**KIRKLEES METROPOLITAN COUNCIL  
INVESTMENT & REGENERATION SERVICE**

**DELEGATED DECISION TO DETERMINE PLANNING APPLICATIONS**

Reference No:	<b>2025/62/91505/E</b>
Site Address:	17, Shillbank Lane, Mirfield, WF14 0QA
Description:	Erection of front porch with roof lift to form rear dormer and associated alterations
Recommending Officer:	Jennifer Booth

**DECISION – CONDITIONAL FULL PERMISSION**

PROJECT TITLE 17, SHILLBANK LANE, MIRFIELD			
DRAWING TITLE BLOCK PLAN			
SCALE 1:200	DRAWN EC	CHECKED JH	PROJECT REFERENCE ODS_23/717
PAPER SIZE A3	DWG NUMBER (20)002	DATE 22/05/25	REVISION /
CLIENT JAKE SINCLAIR

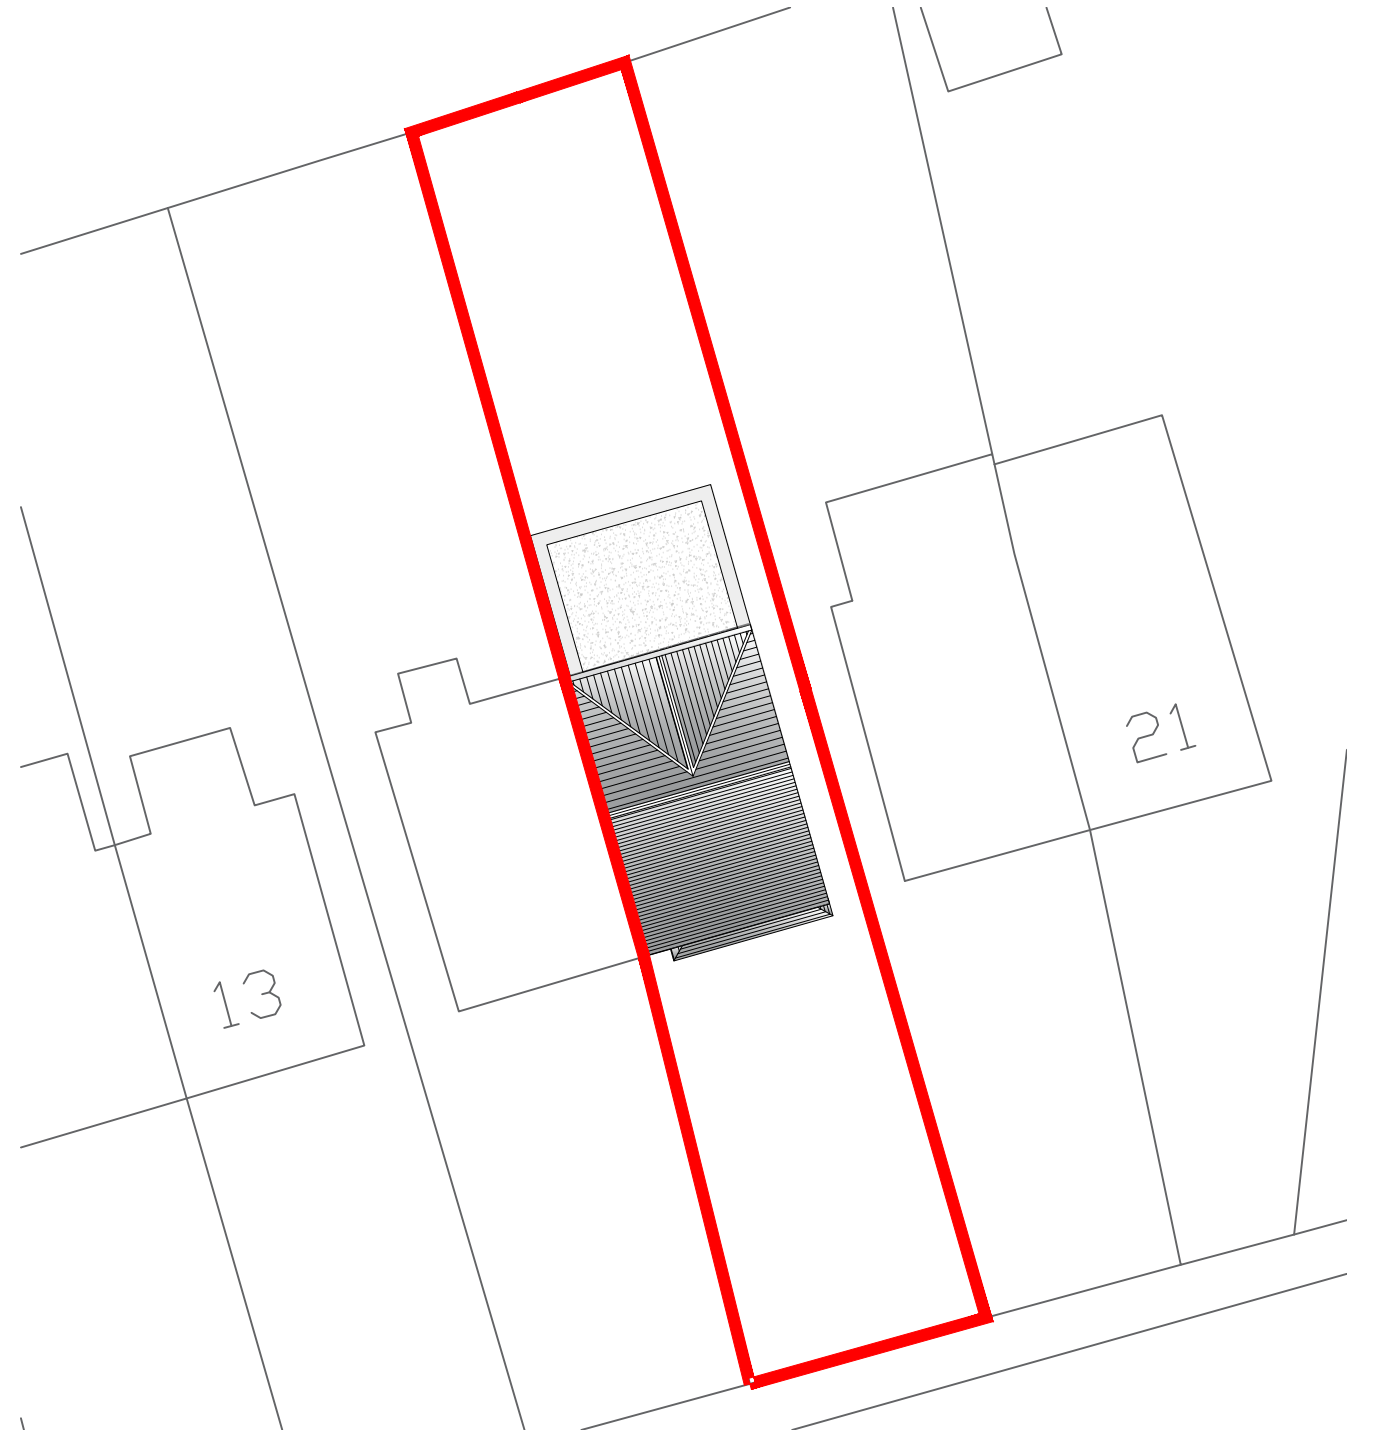
The proposals will result in some intensification of the domestic use. However, the parking area to the side of the property would not be affected by the proposed extension and is considered to represent a sufficient provision. Bin

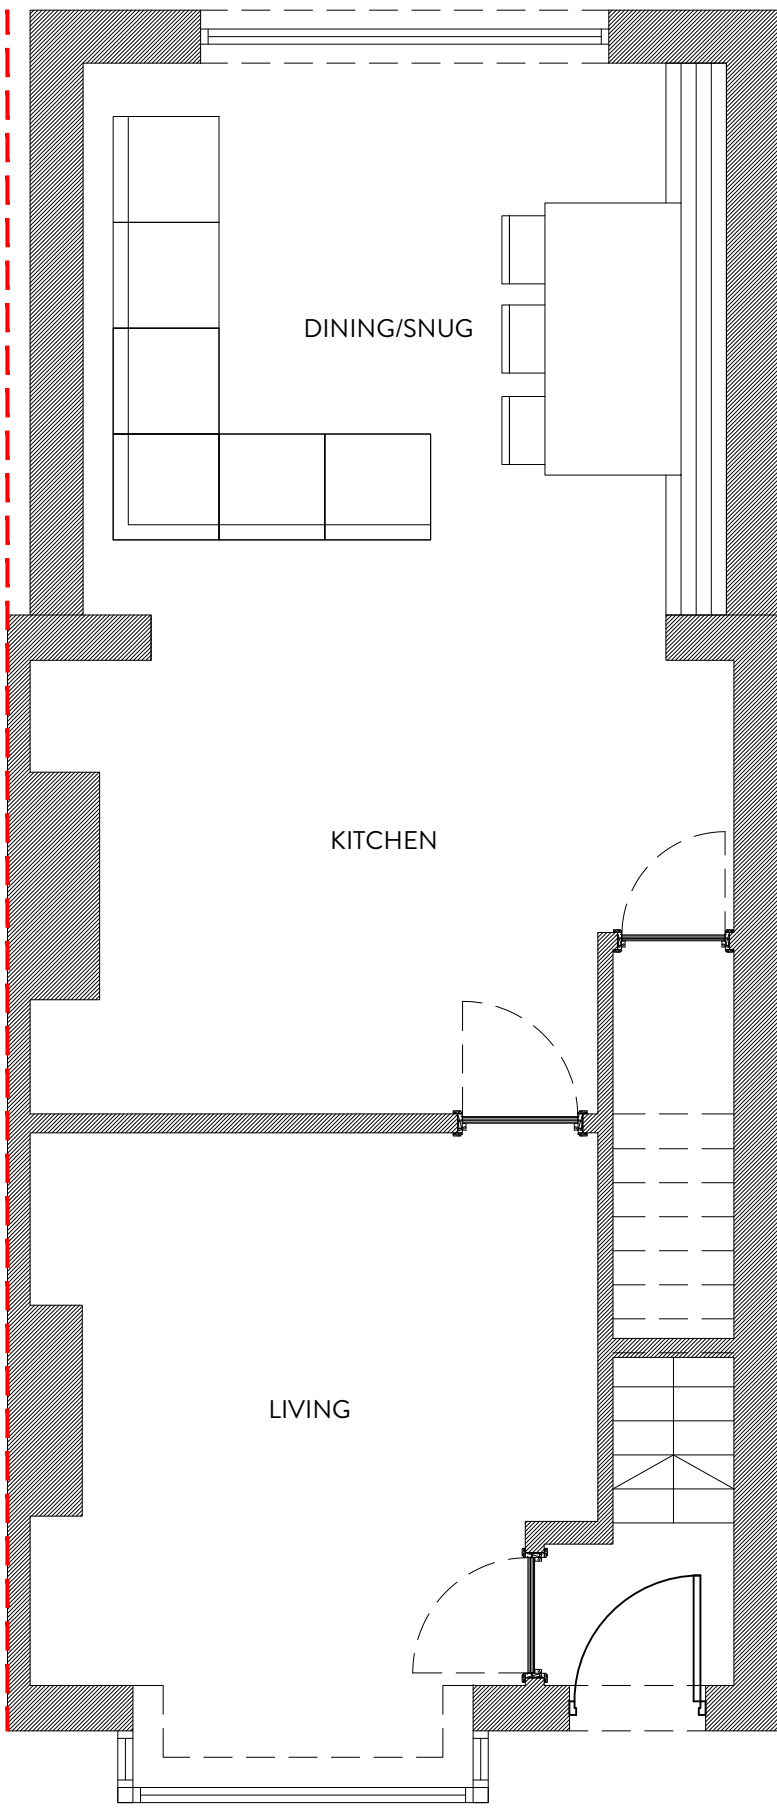
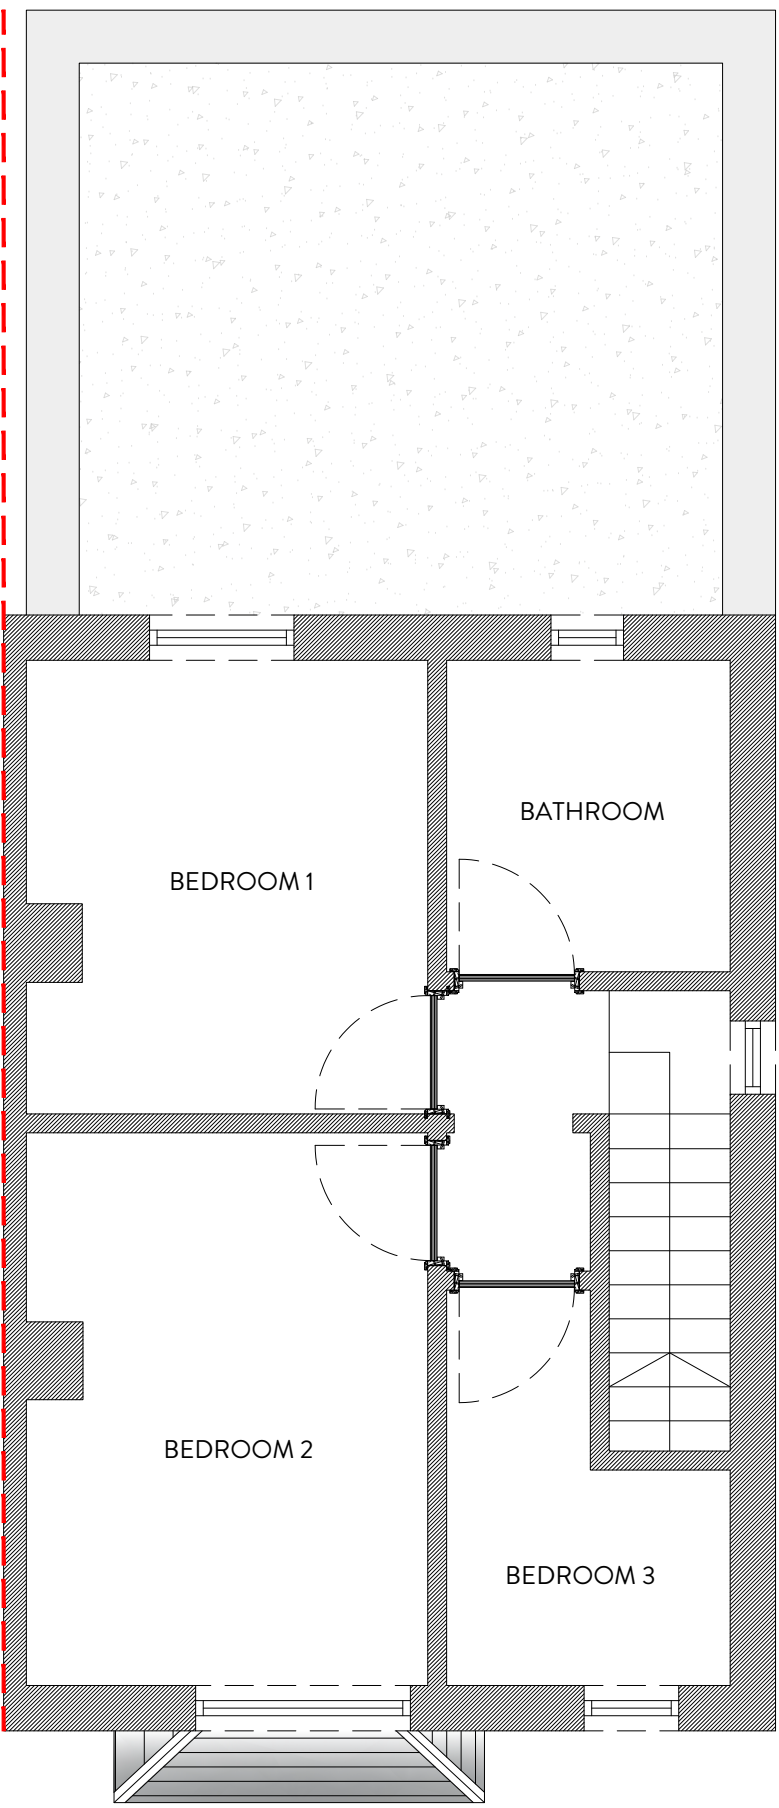
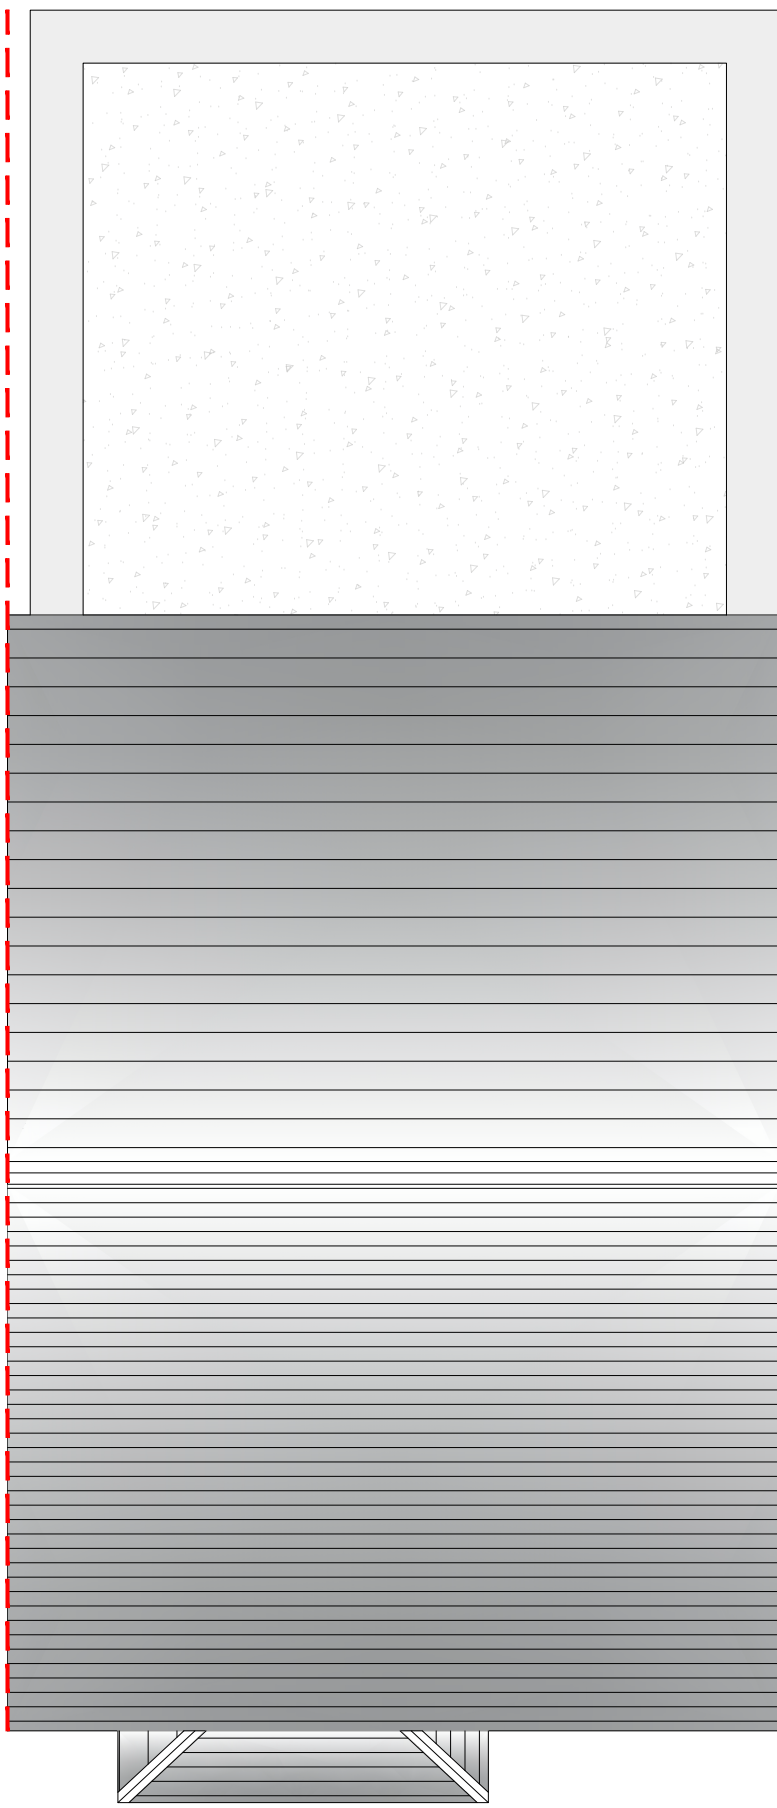
The increase in height and gable extension in the rear roof plane would have no impact on the adjoining dwelling in terms of overshadowing, overlooking or overbearing given the development is within the footprint of the existing house.

The increase in height and gable extension in the rear roof plane would have no impact on the adjacent dwelling in terms of overshadowing, overlooking or overbearing given the development is within the footprint of the existing house.
